Recommendation Report for Planning Permission for Works or Extension to a Dwelling

REF NO: FP/237/20/HH

LOCATION: 30 Davenport Road
Felpham
PO22 7JS

PROPOSAL: Raised deck and increased height to perimeter fence in rear garden.

Proposed Drawing - Rear Garden Plan & Fence Elevations

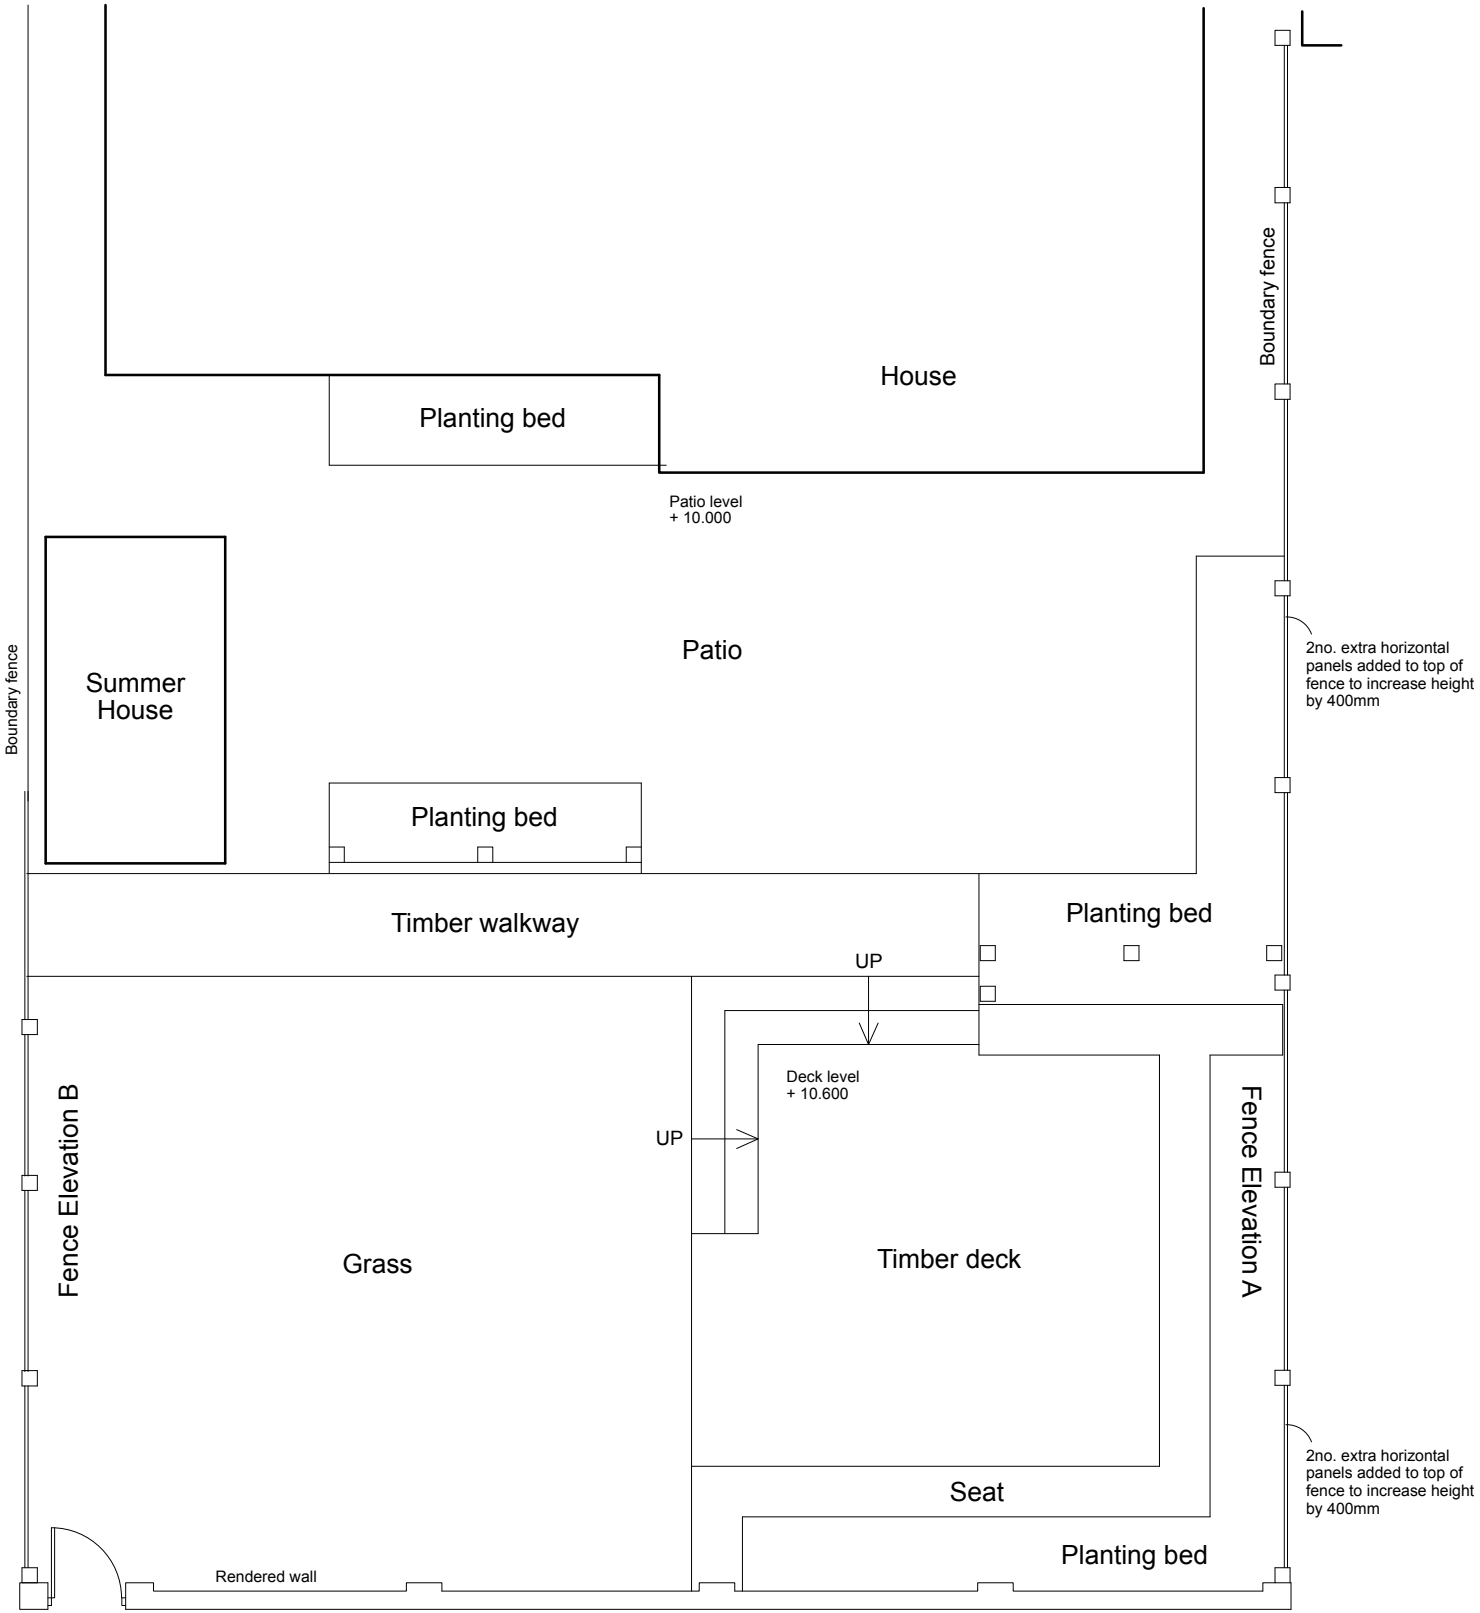
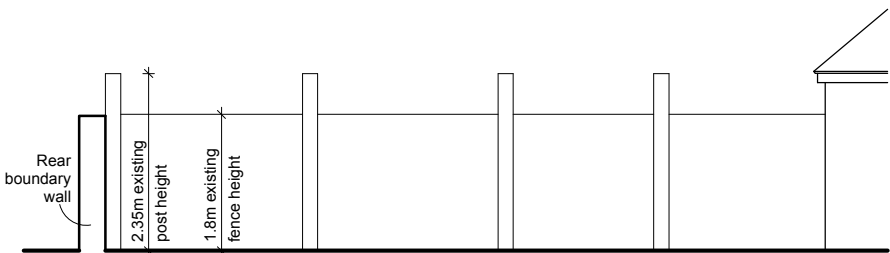
The decking will have a depth of around 7.2m and a width of 6.8m. This will have a height above ground floor level of around 0.6m.

As a result of the height of the decking and existing fence height at 1.7m, this does give rise to some overlooking as it allows for views towards the private amenity space of the neighbouring property to the east at No.32.

As such, the proposal also seeks to increase the height of the fence along the eastern boundary to 2.1m. An additional 2 horizontal fence panels will be added to the existing boundary treatment which increases the height of the fence by approximately 0.4m. There is also planting beyond the fence which helps to screen views. The height is also not considered to be overbearing.

It is considered that with the proposed additional height to the fencing, this would reduce significant views that are currently achieved when standing on the decking. There maybe some minor views still available with the screening reaching a height of around 1.5m when standing on the decking. However, the boundary treatment proposed is considered to reduce views sufficiently so they are no longer significant.

The raised decking is not considered to result in significant overlooking impacts as a result of the increase the height of the boundary treatment.

- 2 The increase in fence height ,shall be constructed within 3 months of the date of this permission and a fence of the approved height shall be maintained in perpetuity.
